December 8, 2020

Re: Chipotle
4331 San Mateo Blvd NE
30-Day Temporary Certificate of Occupancy
Transportation Development Final Inspection
Engineer's/Architect's Stamp dated 5-27-20 (G17D032)
Certification dated 12-1-20

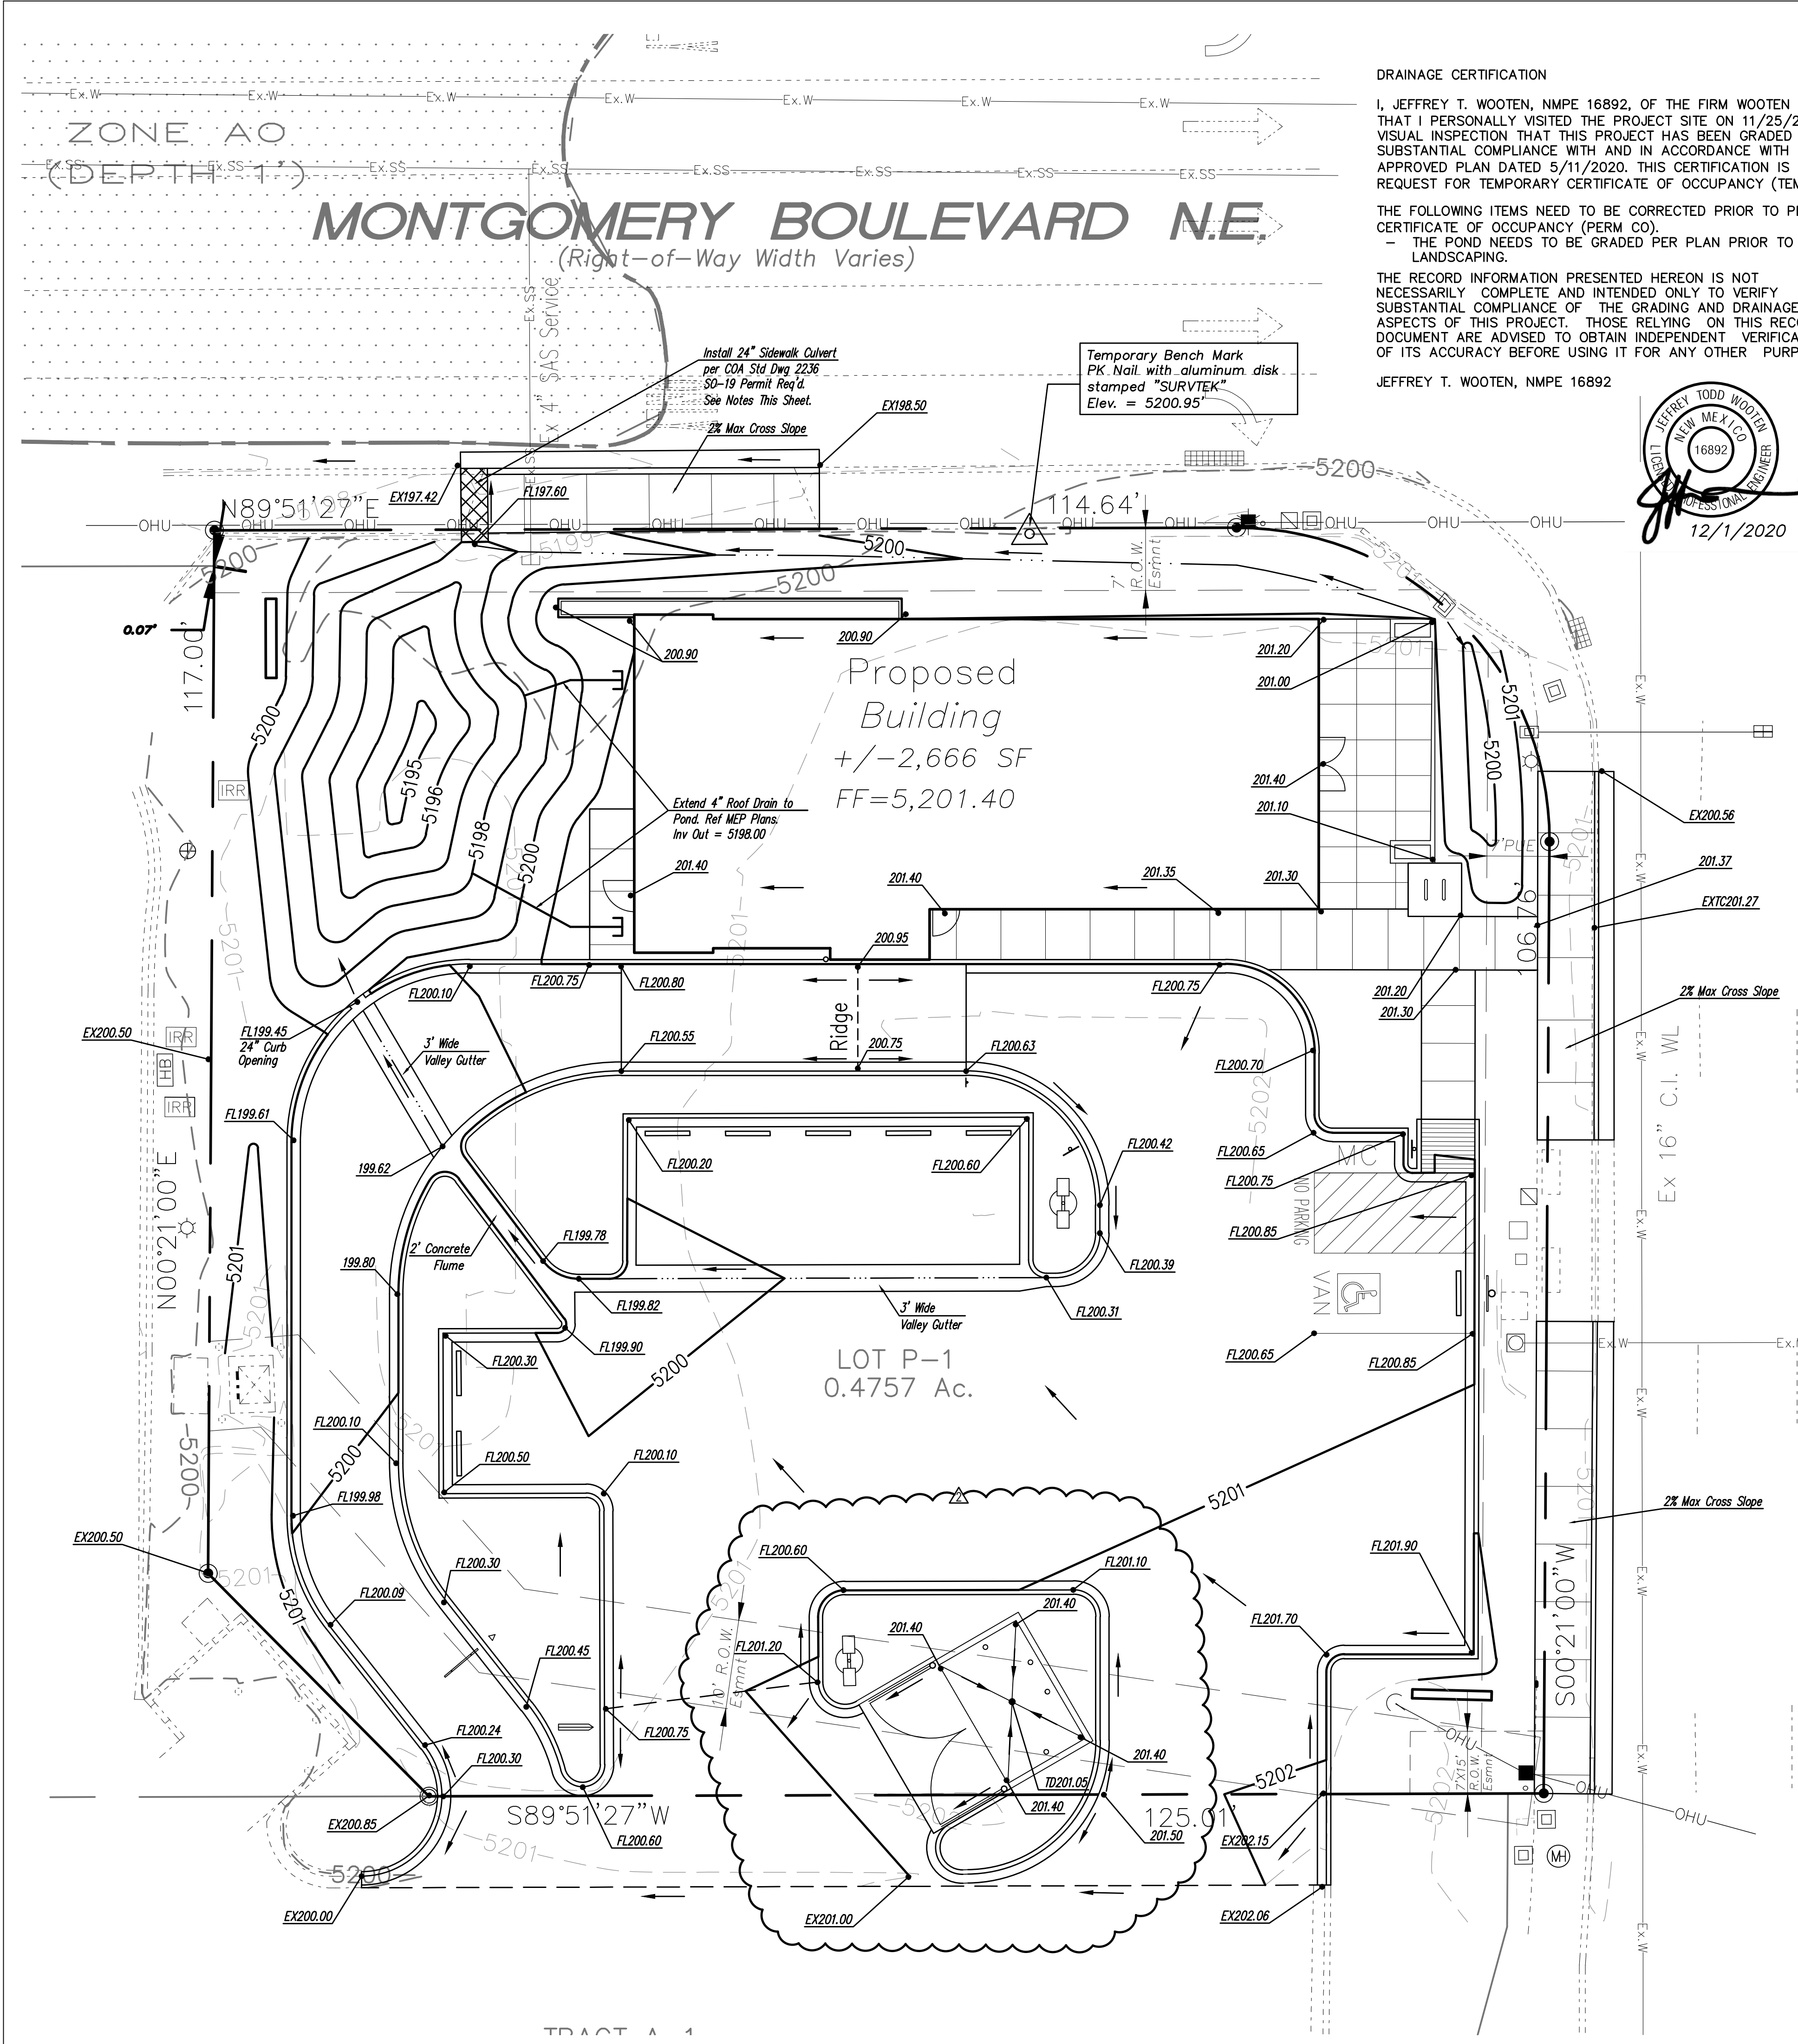
- Remove port-a-potty and piles of dirt on the parking lot.
- Provide backfill between sidewalk and retaining wall along Montgomery.
- Remove debris and clean the site.
- Finish landscaping along San Mateo behind sidewalk and fill behind sidewalk.
- Place the "Do Not Enter" sign and one-way sign that is missing as vehicles exit the drive-thru.
